3/18 Eagle Wing  
Temple Quay  
House  
2 The Square  
Bristol, BS1 6PN

Our Ref: EN070001  
Date: 25 July 2014

## **Application by National Grid Carbon Ltd for an Order Granting Development Consent for the Yorkshire and Humber CCS Cross Country Pipeline**

### **Section 51 advice following issue of acceptance decision**

Foreshore at Barmston Sands, Bridlington  
 Ref: HUMBCC-2014-1-SCLP-JH-Crown Land 1  
 Reproduced from Ordnance Survey map data.  
 Crown Copyright. All rights Reserved.  
 License Number 100055005

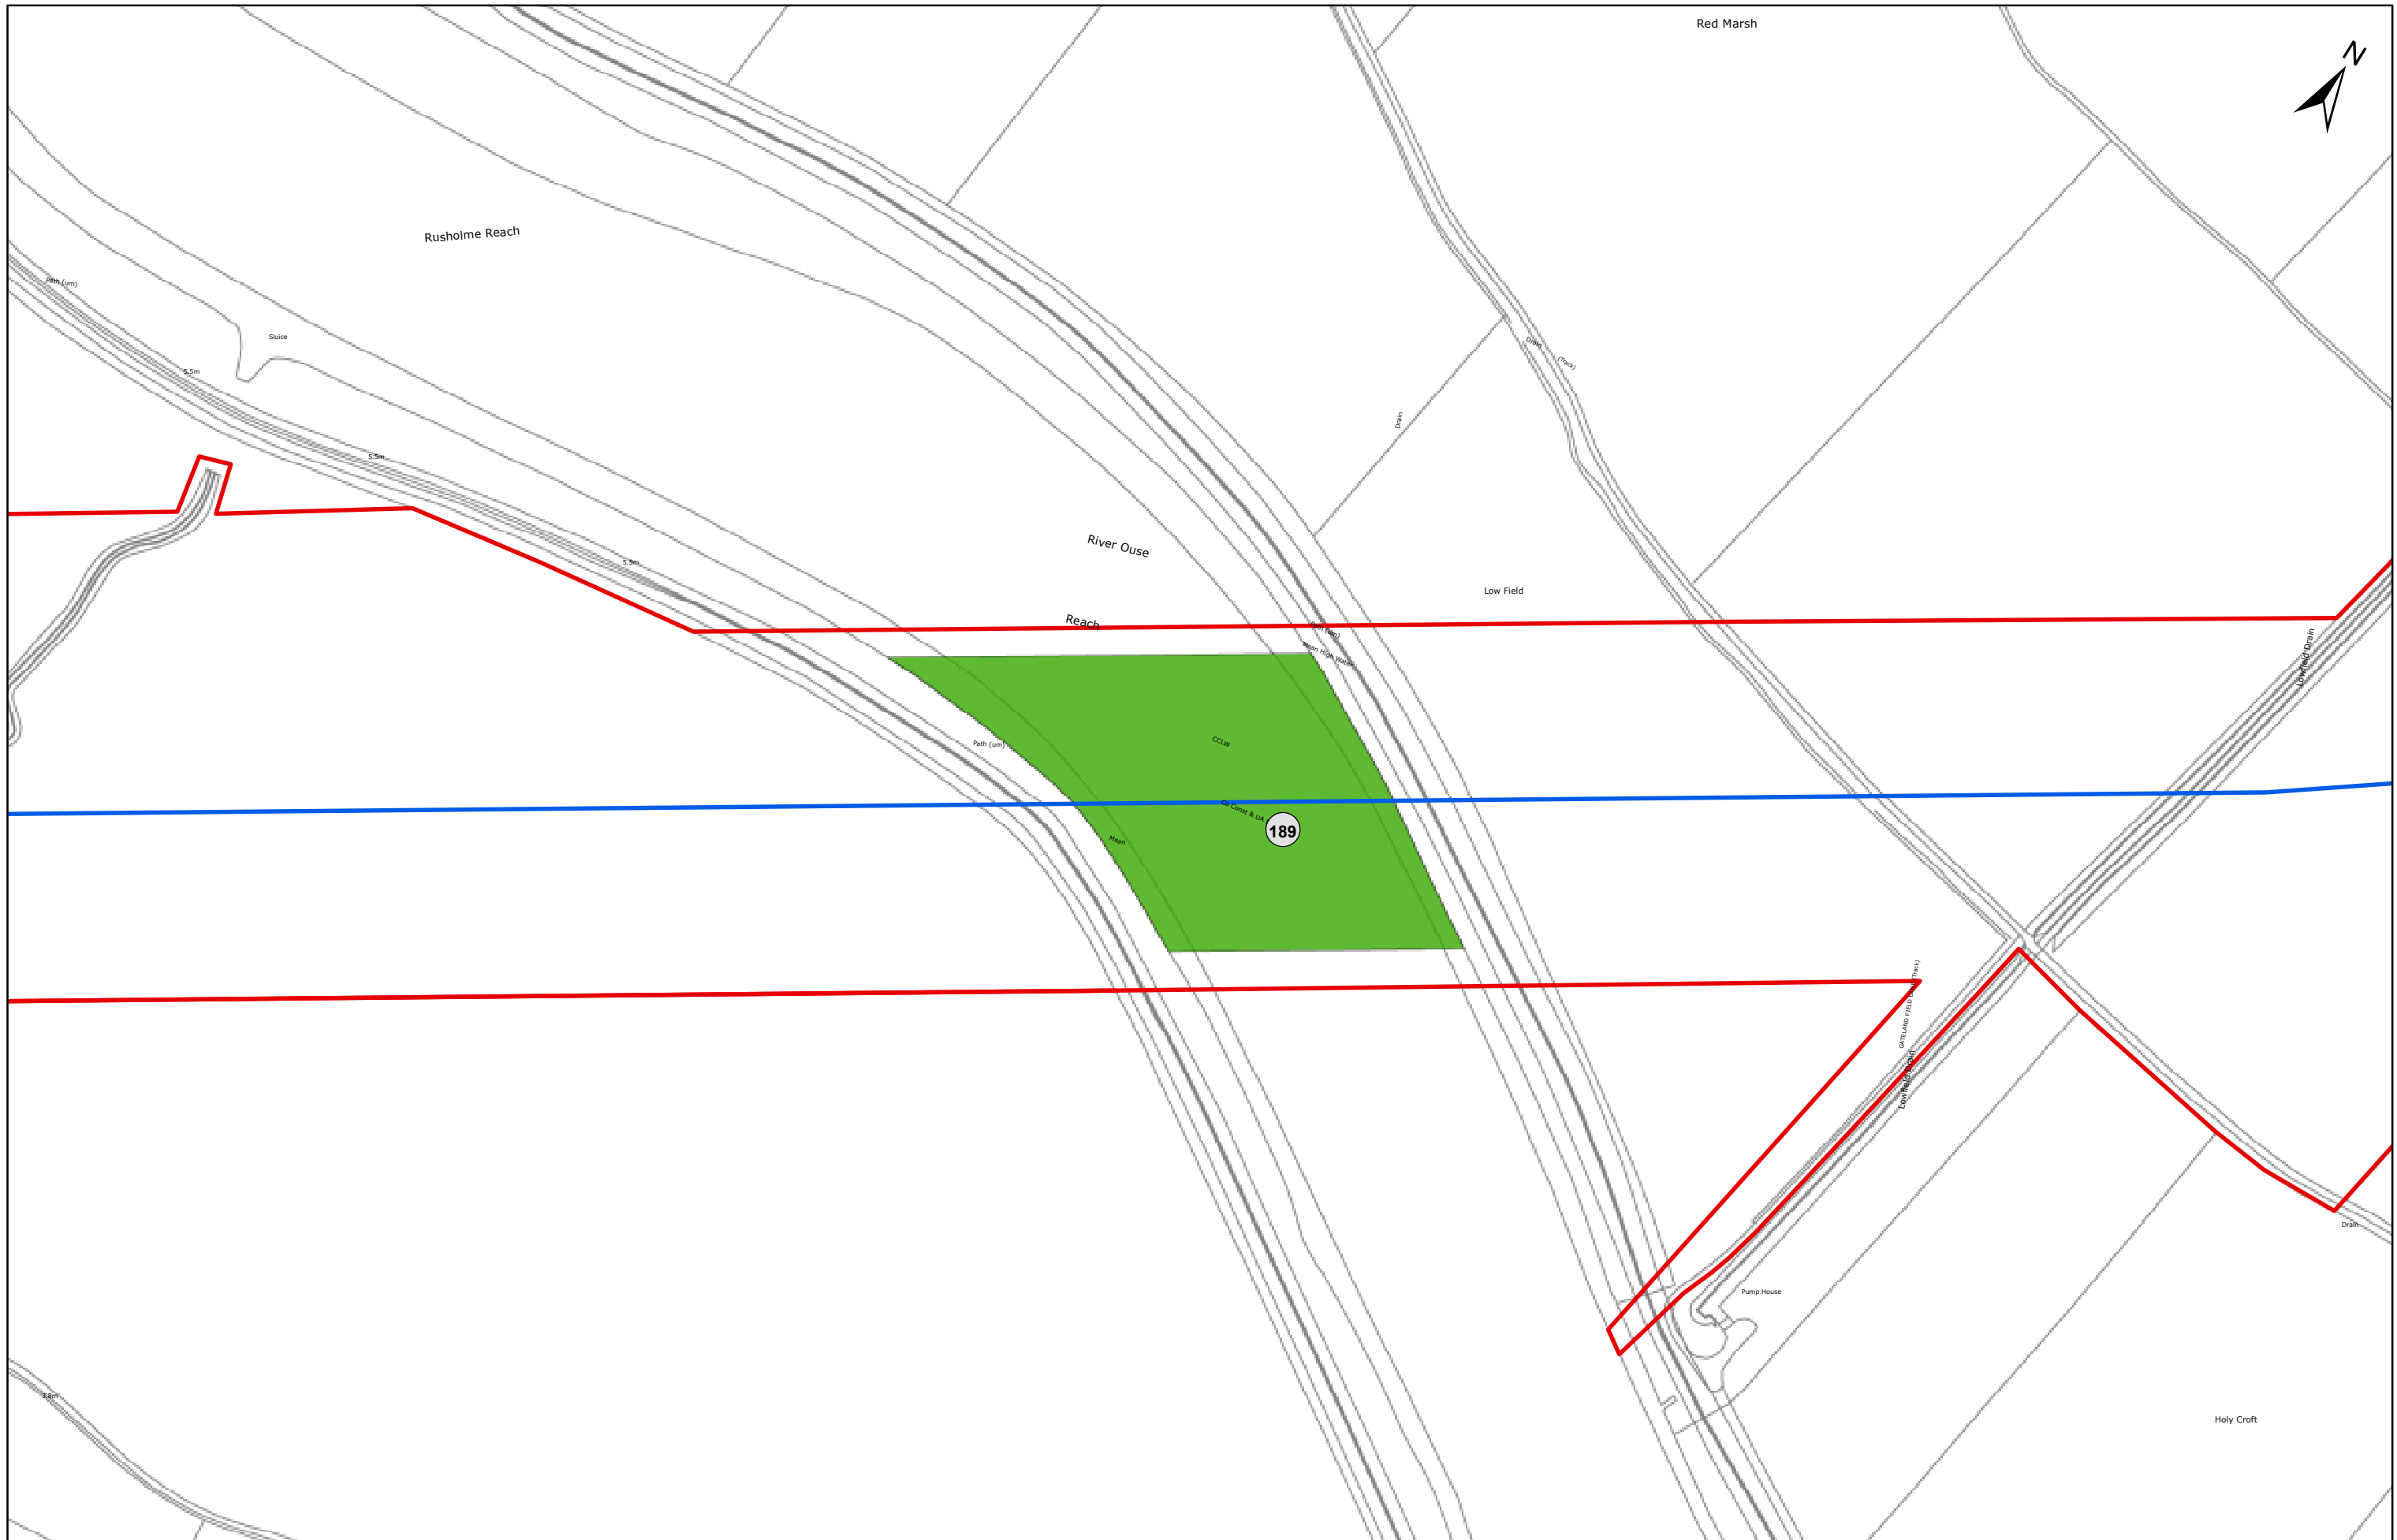
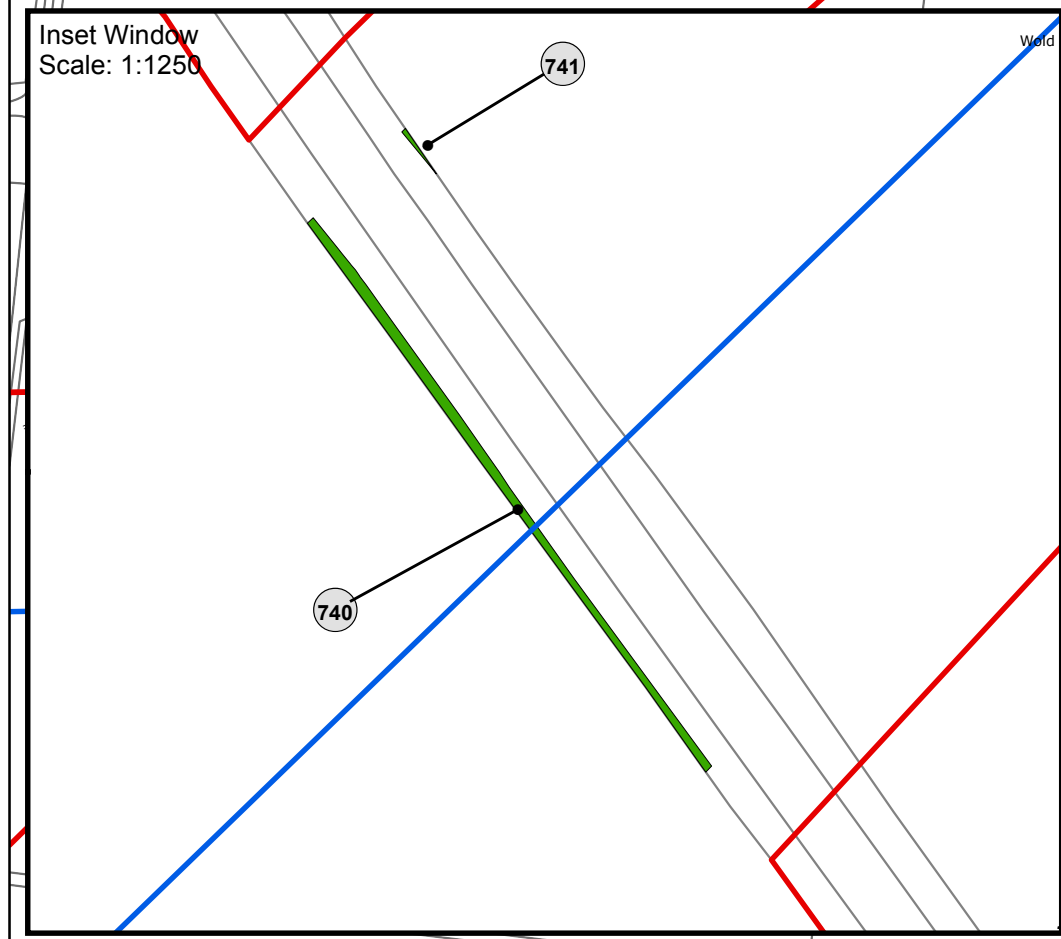
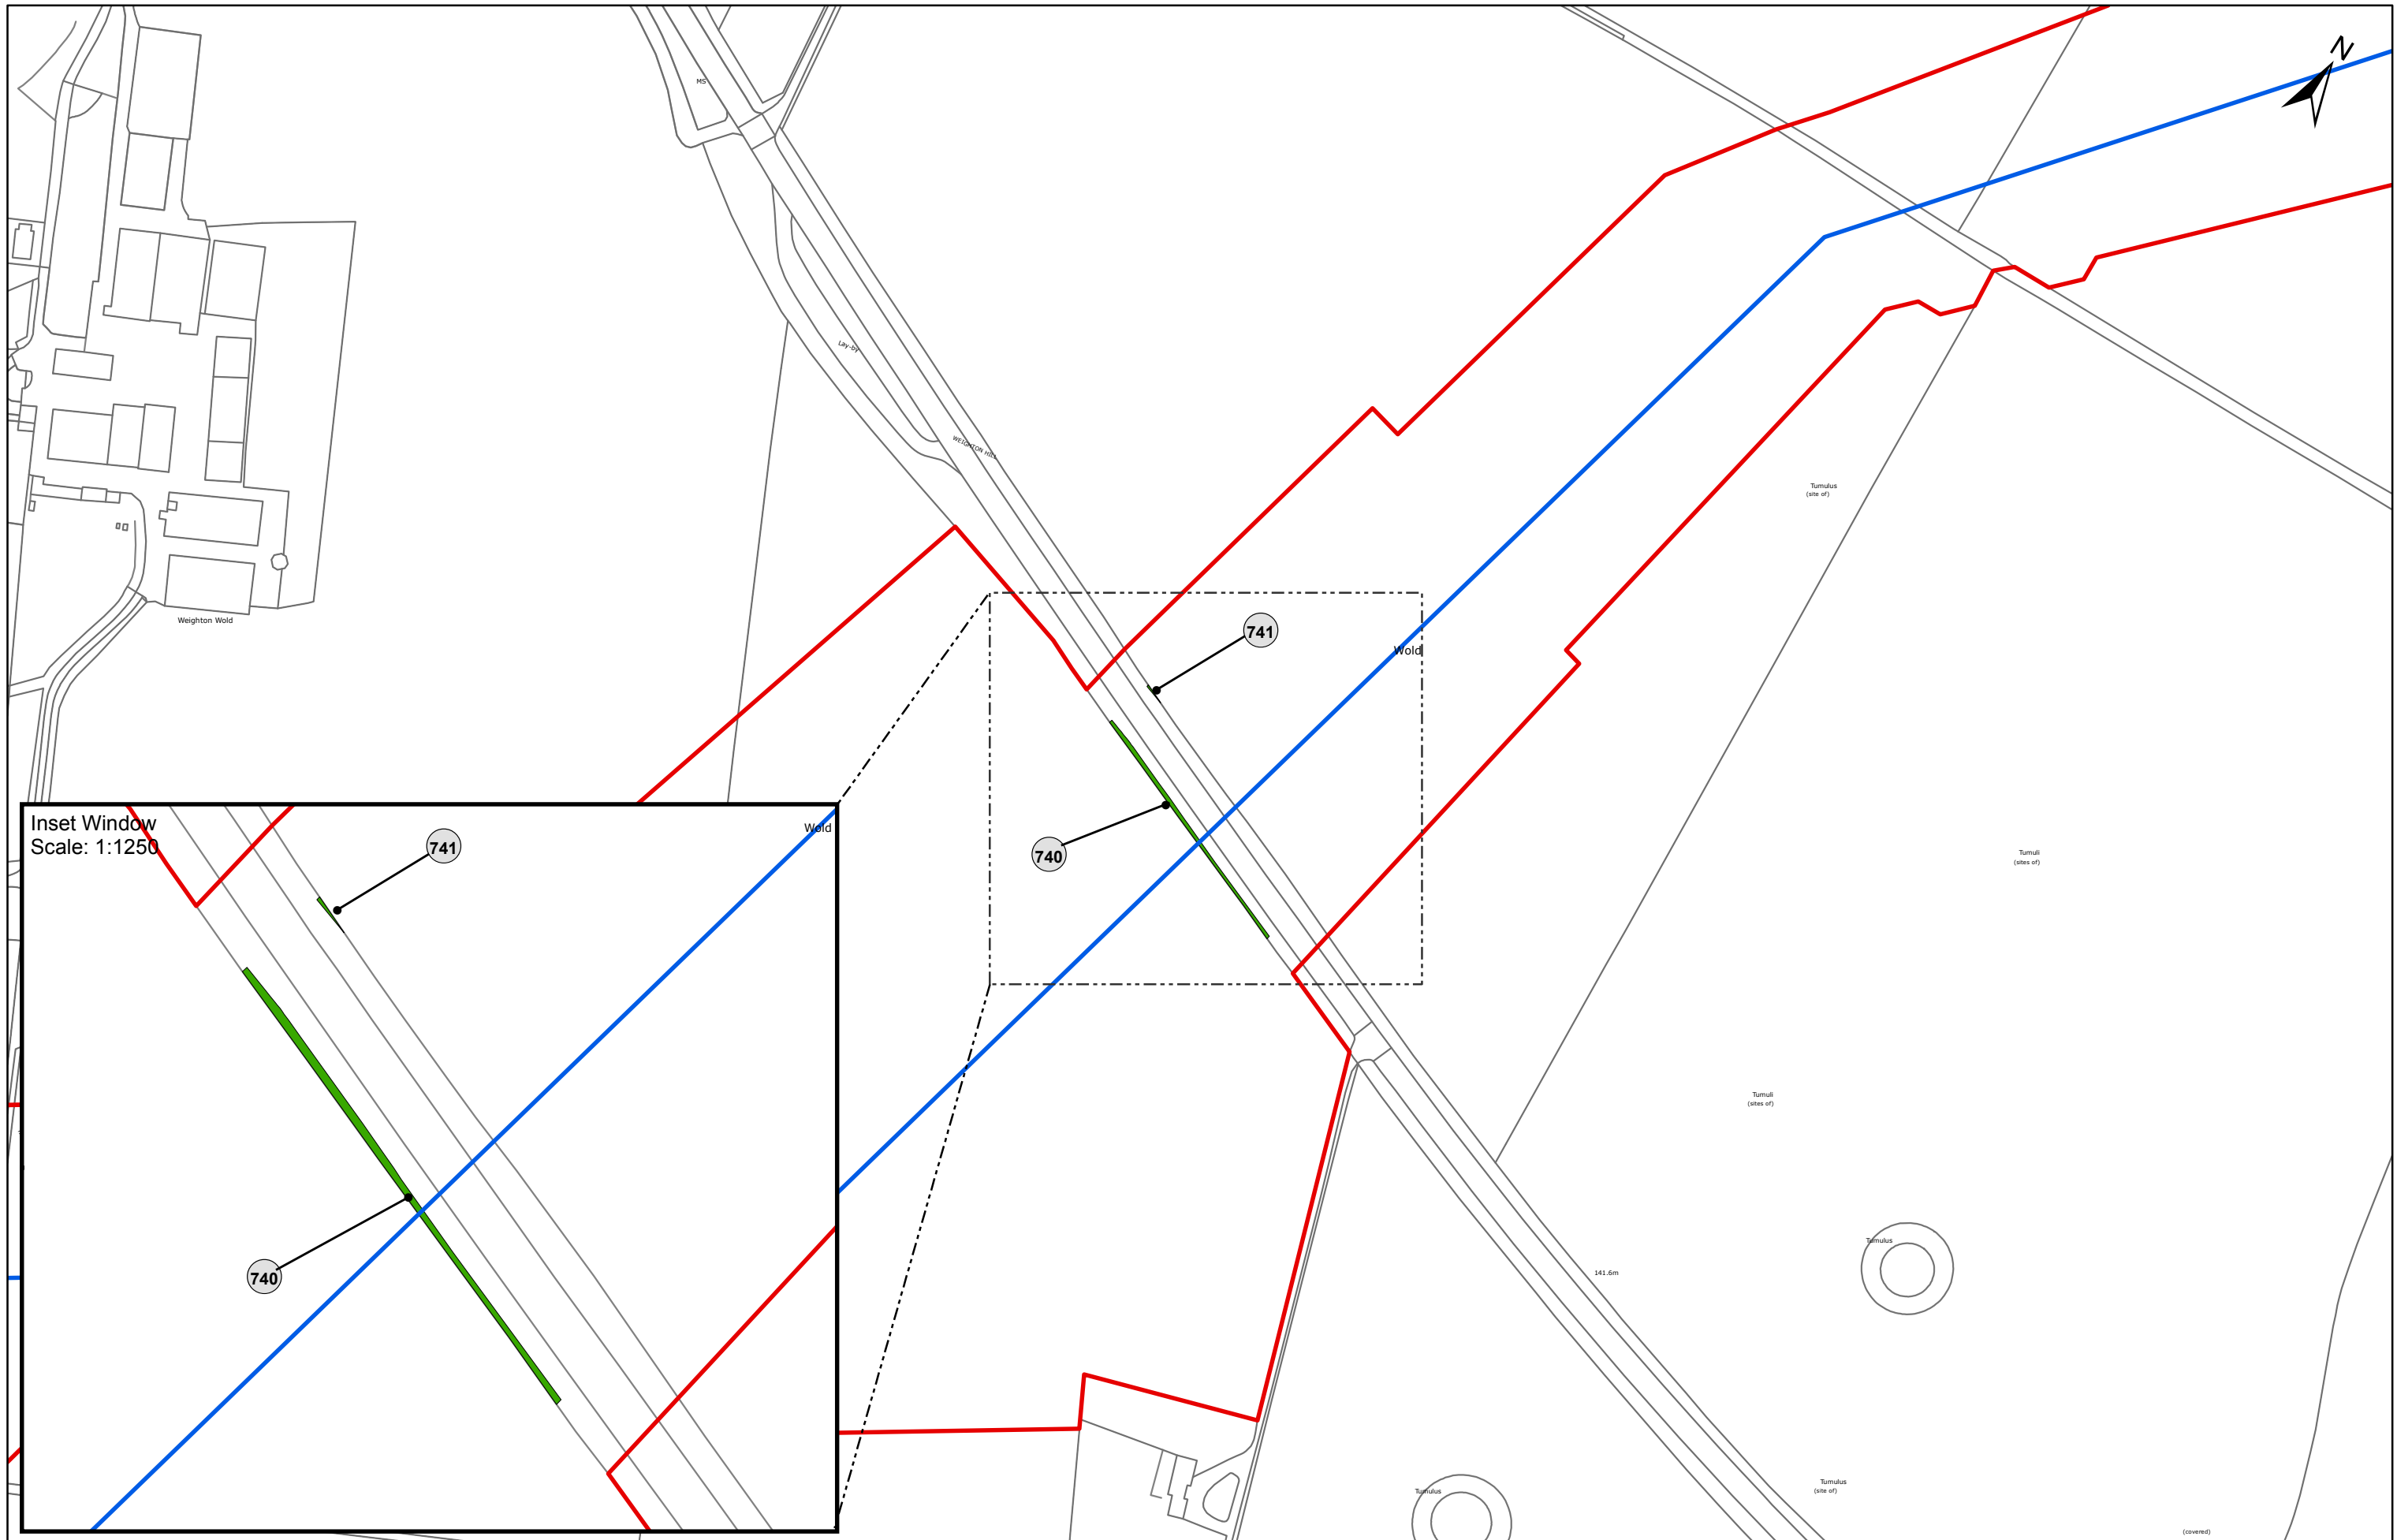
Whilst the Land Plans (Doc 2.1) show all the plots of Crown Land to be used for the purpose of development, the Crown Land Plans (Doc 2.6) only show four plots (plots 189, 740, 741 and 1280) of the twelve plots listed in Part 4 of the Book of Reference (Doc 4.3). The four plots shown on Crown Land Plans (Doc 2.6) currently refer only to the land over which the applicant seeks to acquire permanent rights. The plans do not currently show the other eight plots over which the applicant seeks to acquire temporary rights.

In addition, the Crown Land Plans are currently not accompanied by a key plan, as required by Regulation 5(4) of The Infrastructure Planning (Applications: Prescribed Forms and Procedure) Regulations 2009.

The applicant is encouraged to provide updated copies of the Crown Land Plans (Doc 2.6) that clearly identify all plots of land in accordance with Part 4 of the Book of Reference (Doc 4.3). These plans should be accompanied by a key plan.
